Our Ref: R/210/17/HH
Your Ref:

Town & Country Planning Act 1990 (as amended)
Town & country Planning (Development Management Procedure) (England) Order 2015
Application for Planning Permission for Works or Extension to a Dwelling

Development Retention of wooden gate & raised bed planter to the front.
Location 7 Orchard Gardens Rustington

Drawing Title  
Planter Plan and Photo Schedule

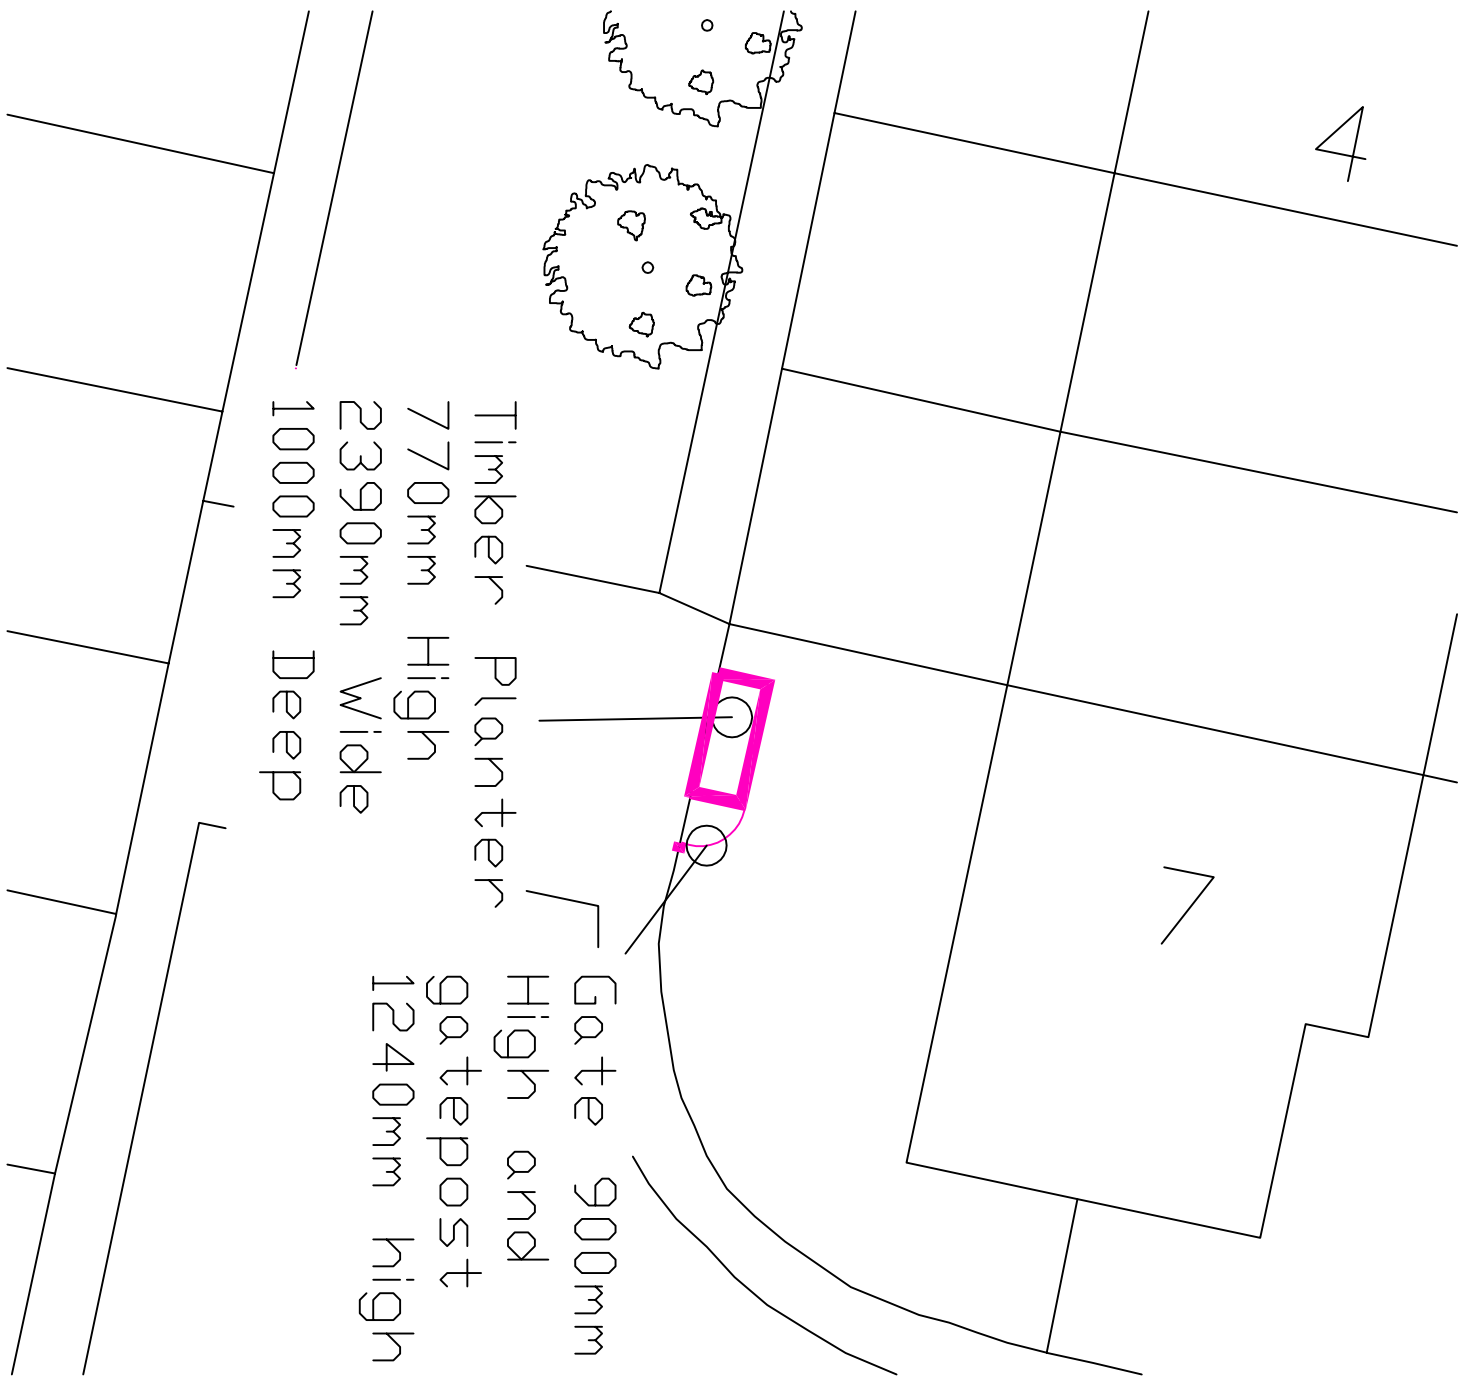
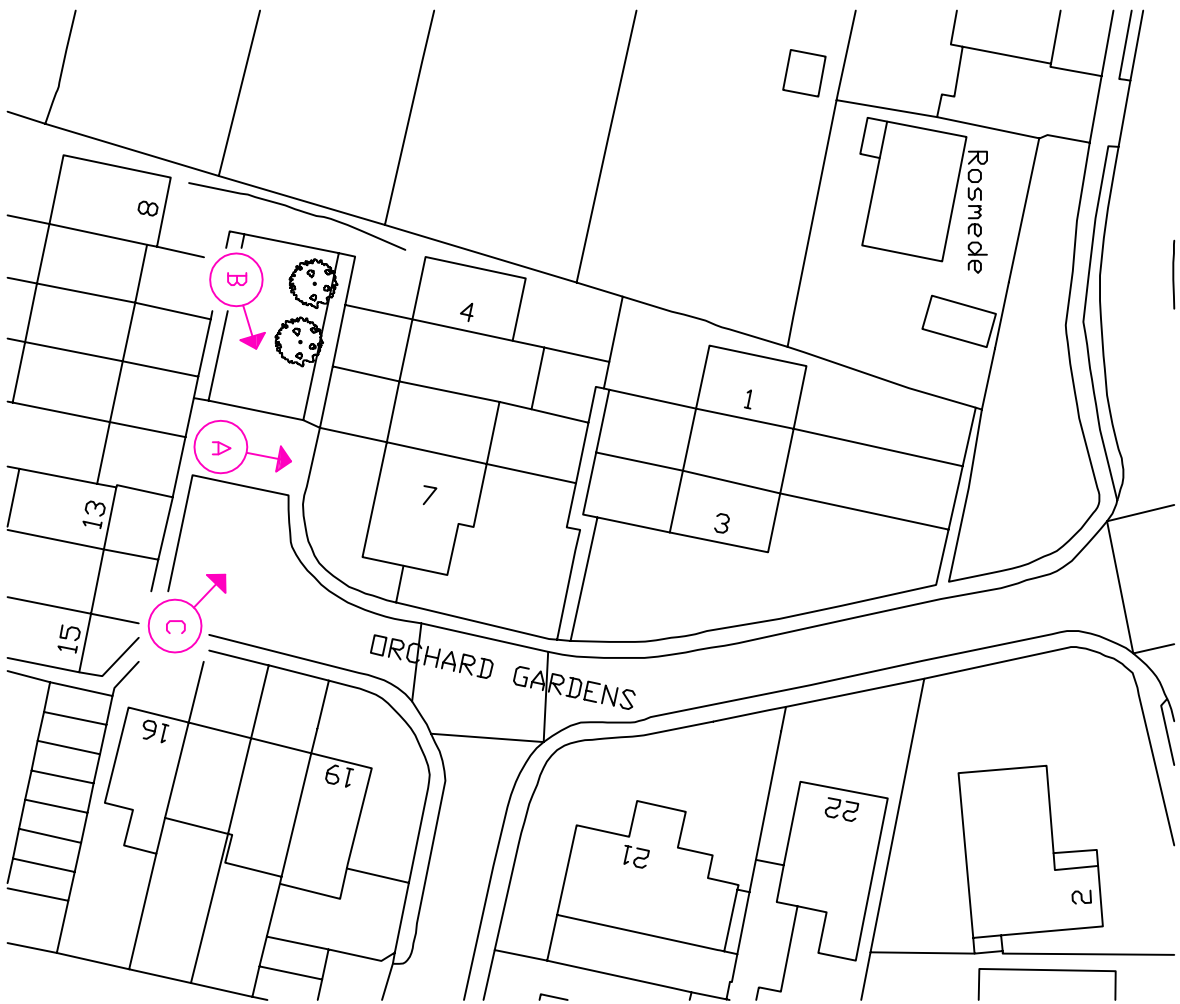
Please provide a measurement for the height of the gate post in metric.

Please provide a measurement for the depth of the planter in metric.
